**From:** Hilary Ellis  
**Sent:** 18 March 2021 17:08  
**To:** 'Vivian, Richard' [REDACTED]  
**Cc:** Joely Norris [REDACTED]; Craig Campbell  
[REDACTED]; Pickering, Jack [REDACTED]  
**Subject:** RE: A47 Modelling - LLFA Comments

**From:** Ellis Hilary [REDACTED]  
**Sent:** 04 March 2021 14:16  
**To:** Pickering, Jack [REDACTED]  
**Cc:** Joely Norris [REDACTED]; Craig Campbell [REDACTED]  
**Subject:** A47 Modelling - LLFA Comments

- FEH Hydrological Assessment (HE551494-GTY-EWE-000-RP-LE-30002 | P01.03)
- Hydraulic Model Report (HE551494-GTY-EWE-000-RP-LE-30003 | P01.02)

- 10% AEP Flood Depth (m)
- 0 - 0.2
 - 0.2 - 0.4
 - 0.4 - 0.6
 - Wittering Brook Watercourse
 - A47 Culvert

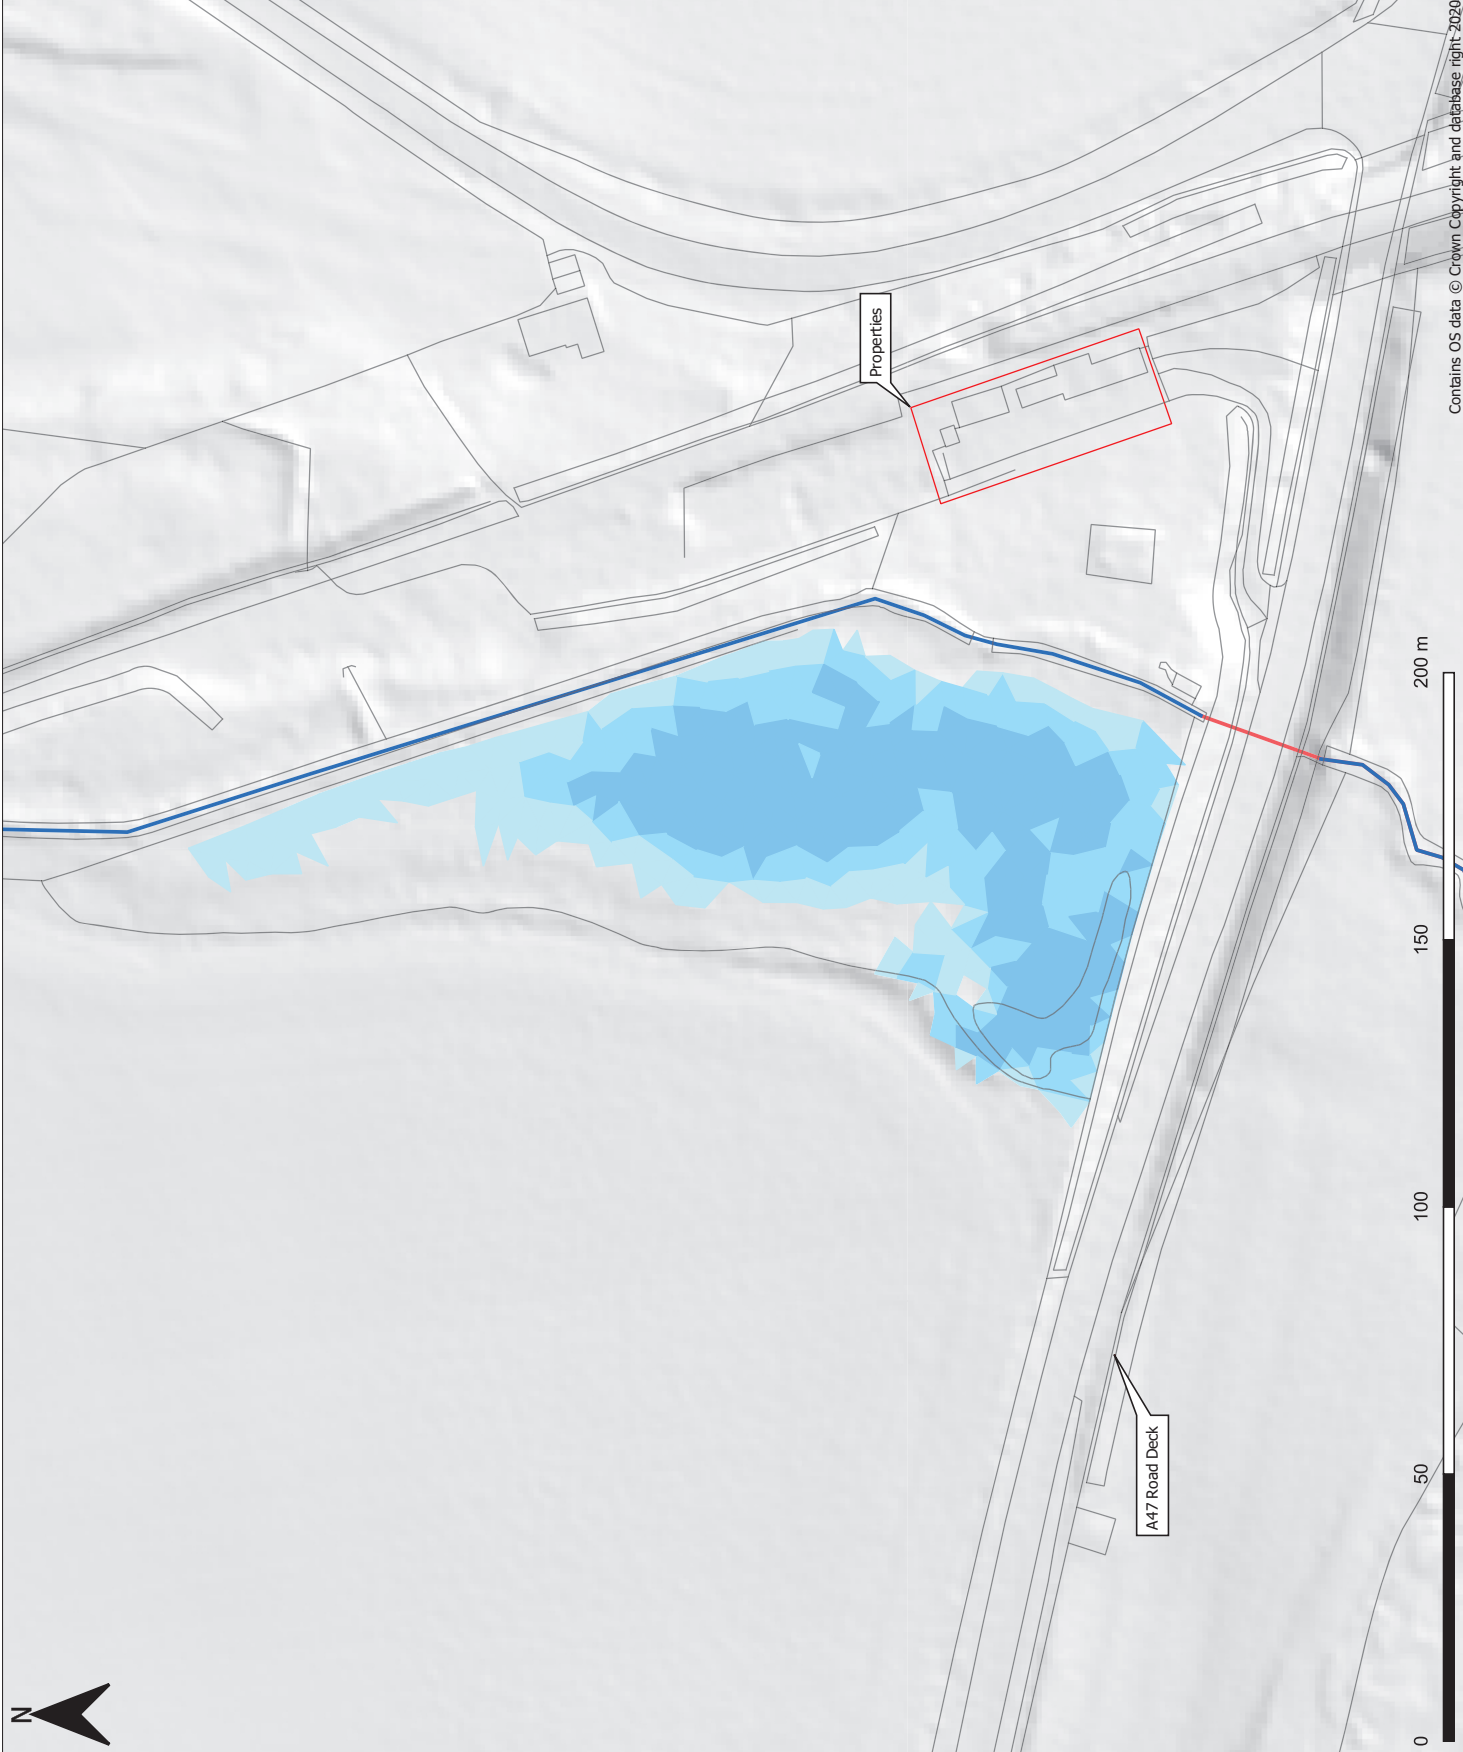
Based on the above, the LLFA would not raise any objection to the preferred culvert arrangement – Option 2b. We would however request some additional information as outlined below. It is our understanding that this option consists of a 2.5 x 2.5 m concrete box culvert over a length of 60m (carriageway width). The modelling suggests that whilst the proposed A47 embankment will encroach onto the floodplain of the Wittering Brook, the need for floodplain compensation is negated by the installation of a culvert of the above dimensions (these are larger than the existing culvert). Hydraulic modelling demonstrates that during a 1% AEP plus 65% climate change event, the increase in flood depths on the floodplain are minor; however during a > 10% AEP event there appears to be quite

widespread 'detriment' across the floodplain of Wittering Brook (see below). We request details of the depth of detriment (m) so we can ascertain the impact on the floodplain in this location.

Thank you for sharing this. Based on the plan, given the increased depths are almost entirely <0.2 m across the floodplain, we wouldn't raise an objection.

Please see attached for updated detriment maps for the A47 Wansford scheme. The 10% AEP event does increase flood depths across the Wittering Brook floodplain; however, only to a maximum depth of 0.2m. With that being said, the detriment maps also show betterment in areas across the floodplain to a maximum depth of 0.2m. This is likely to be due to variations in the model mesh which have been generated from LiDAR. It's important to note the large increases in flood depths along the toe of the scheme embankment are as a result of a drainage channel stitched into the LiDAR which is ultimately mis-represented in the model mesh. Flood depths along the drainage channel line are not a fair representation of detriment/betterment in the floodplain.
